DESIGN AND ACCESS STATEMENT

50 King Street,
Clitheroe

Planning Application submission for
Proposed Rebuilding of Rear Steps and Garage Alterations.
Job No: 2326 - 23.06.2017

IWA Architects

Proposed Garage Plan and Elevations

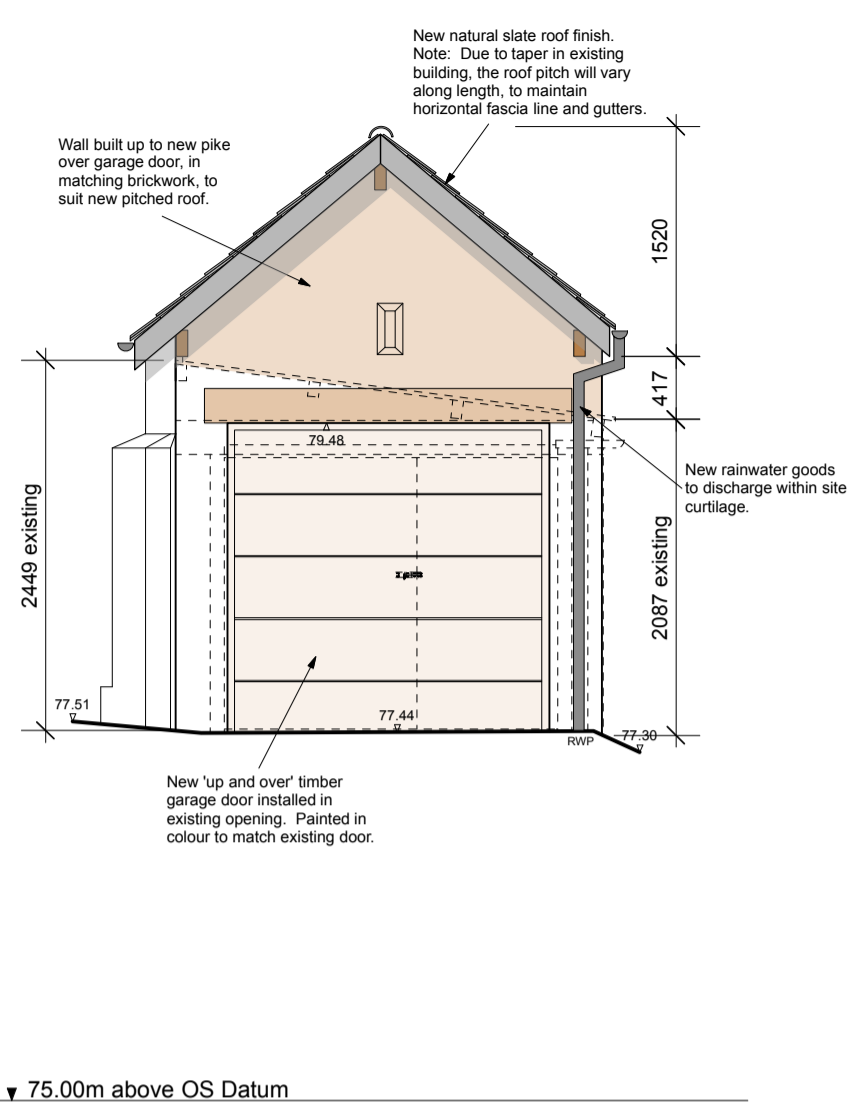
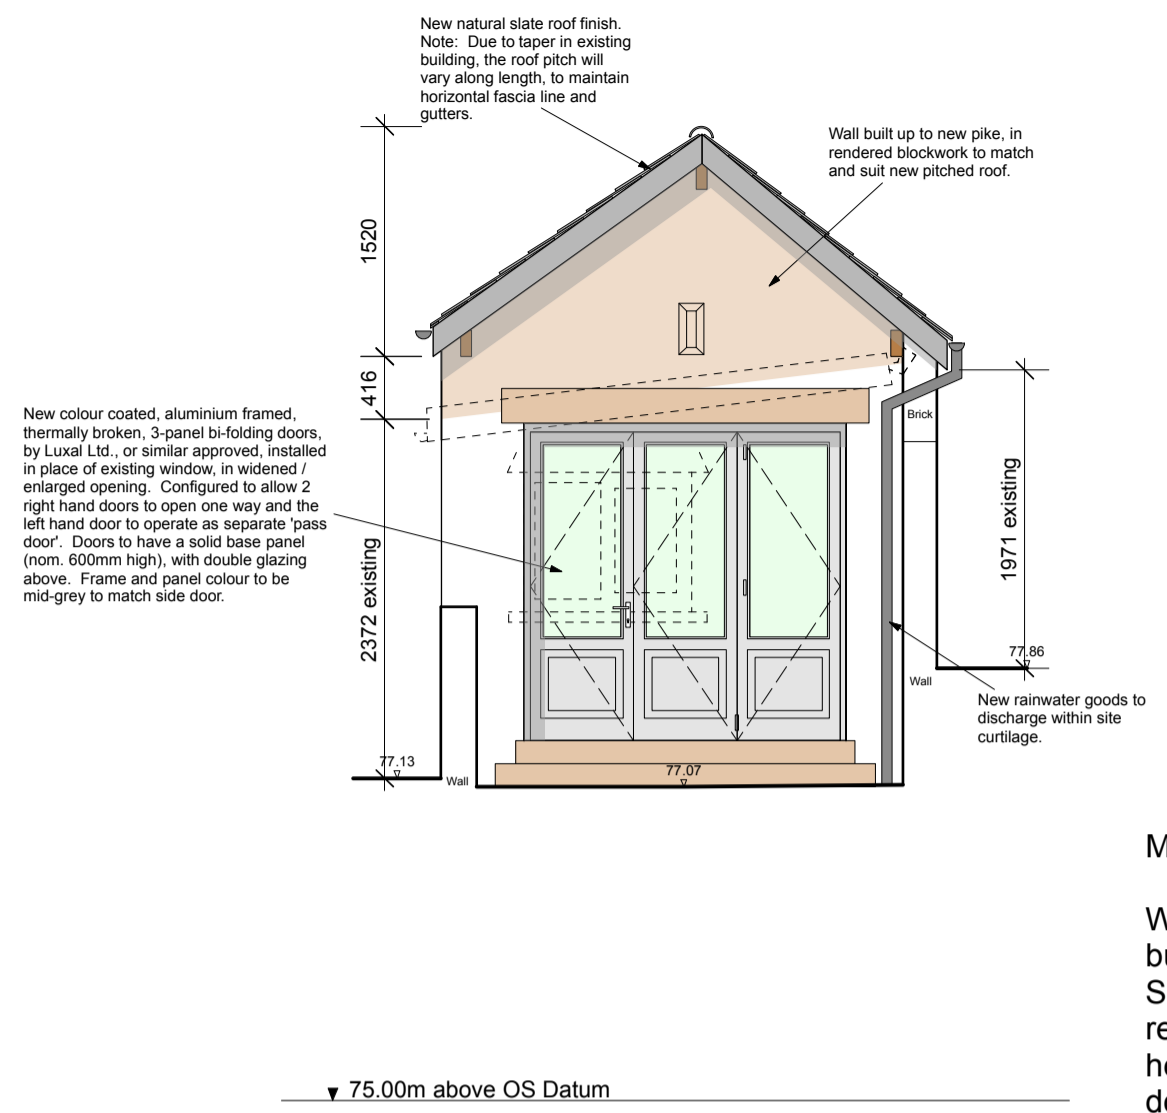
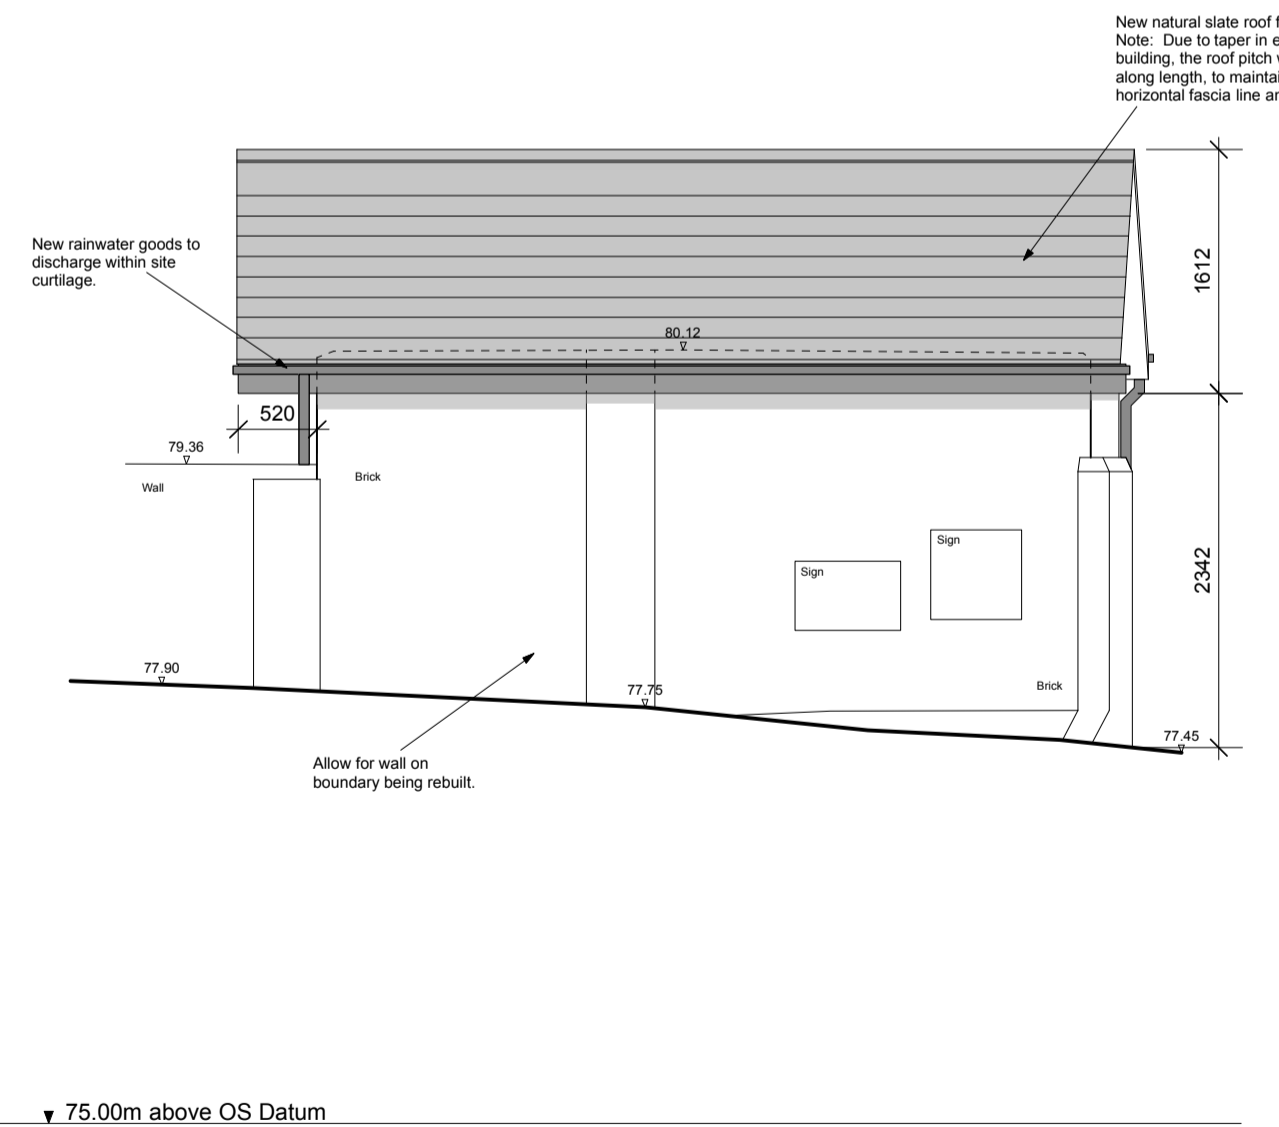
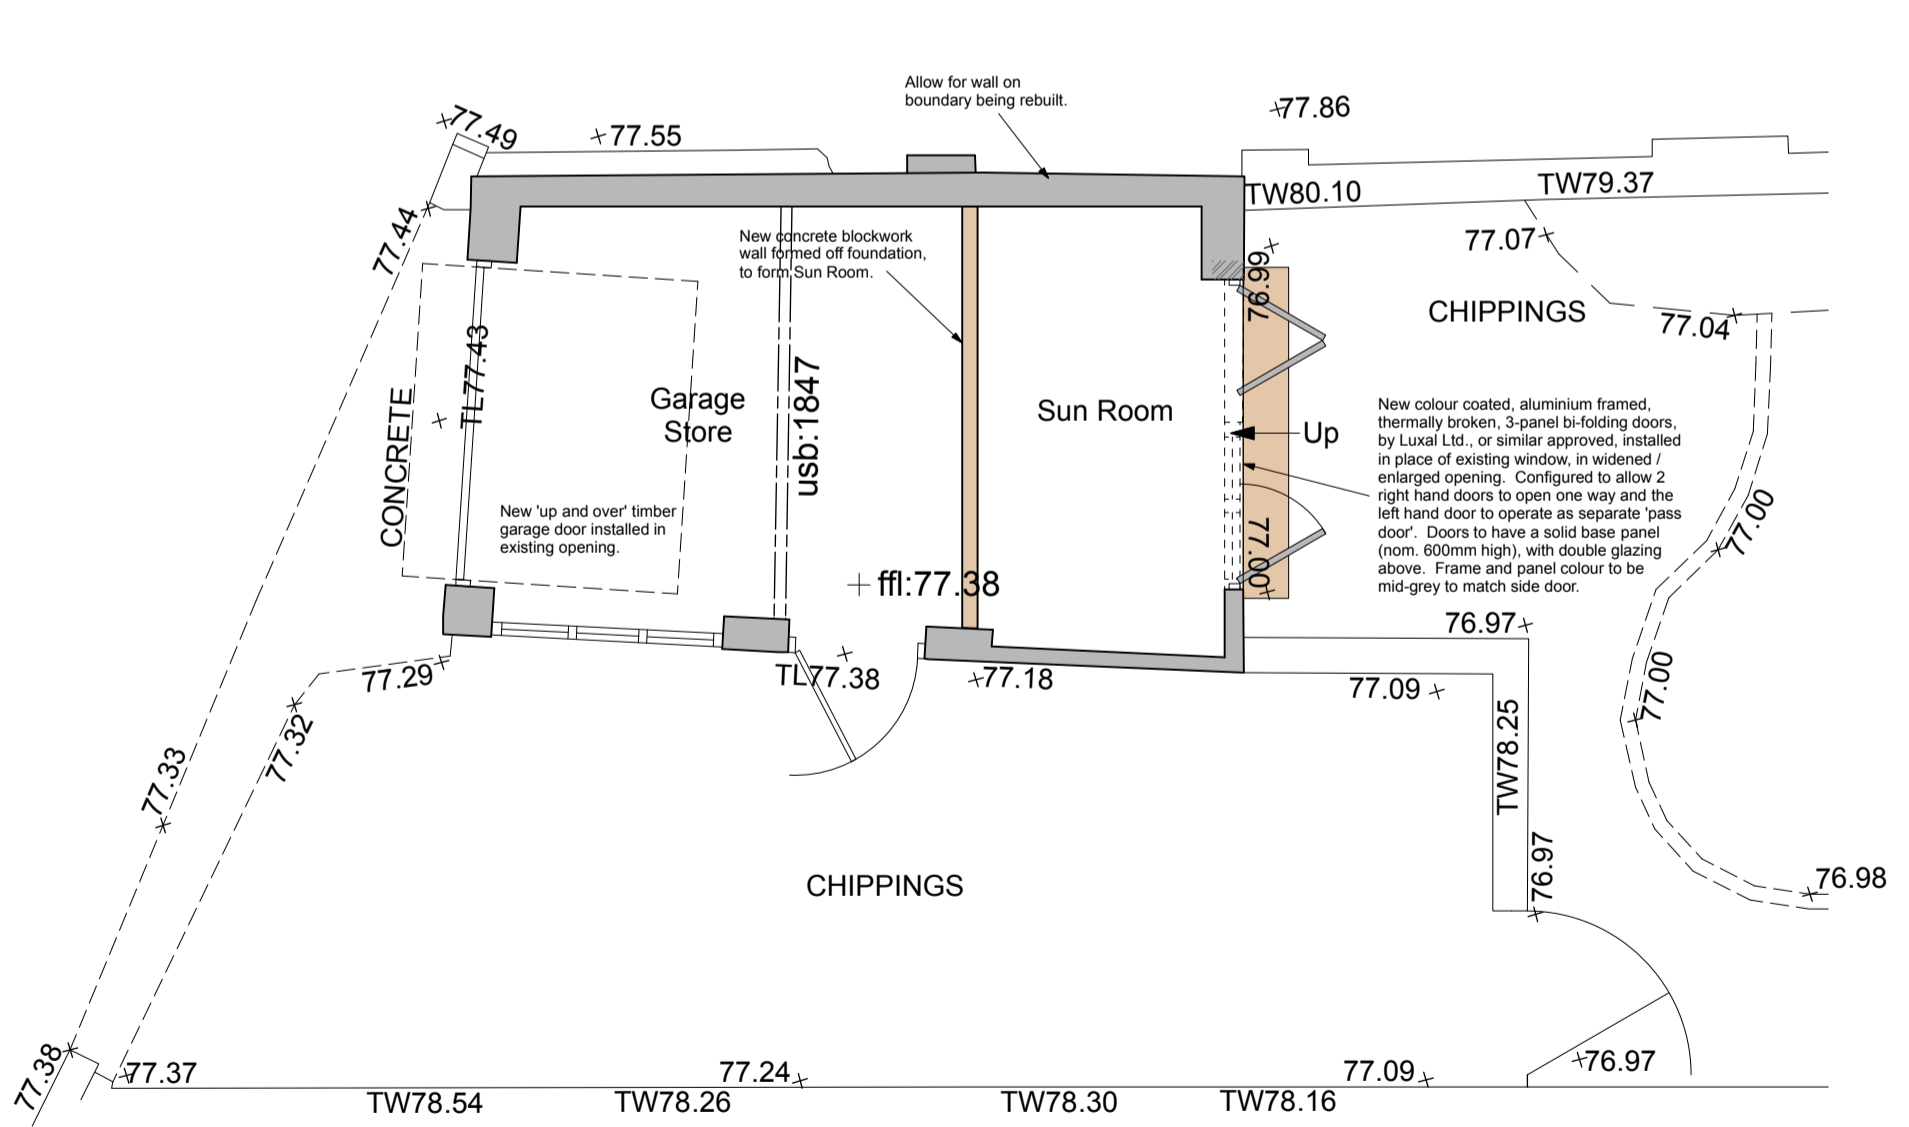
"...With regards to the proposed sun room and alteration to the roof I note that the height of the roof would increase by approx. 1.7m and due to the width of the building the roofline would appear prominent. In my opinion the resultant changes would result in a disproportionately sized building which appears prominently within the public realm detracting from the visual appearance of the property it relates to and the wider Conservation Area..."

"... I have no objection in principle to the works that are proposed to the rear elevation of the property to create a new stairwell, landing and balustrade. I have no objection in principle to the replacement of the sloping roof to the garage with a pitched roof however not of the height proposed. In my opinion, the height of the building as a result of a replacement pitched roof should be no more than 3 metres. Materials to the

north, west and east elevation should match the existing red brick. I have no objection to the use of render and the aluminium framed opening to the south elevation.”

Initially, IWA made an assessment and determined that the actual proposed increase in height would have been approx. 1.5m, measuring from where the existing low pitched roof abuts the boundary wall, to the proposed new ridge.

It was felt that the height of the existing neighbouring wall to The Old Post House dictated (to an extent, with minor alteration), the eaves height of the proposed dual pitched roof, but the restriction of the max. 3m ridge height meant that the pitch would be way below the recommendation for slate roofs at approx. 17°.

At first we enquired if a compromise could be agreed to split the difference at 3.5m to the new ridge, which would produce a more aesthetic (and compliant) 32.5° pitch approx. We hoped this would also satisfy one of the Client’s requirements for the project - to create some storage in the roof space of the Garage.

However, the Client felt that the compromise was unjustified on the basis that the adjacent Old Post House, Dawson’s Department Store and the Health Centre on the opposite side of the rear alley, all had outbuildings, garages, stores, etc., that were greater in height than that which is being proposed for their scheme. Therefore the drawings being submitted for the Planning Application have been unaltered apart from notes regarding the materials being used.
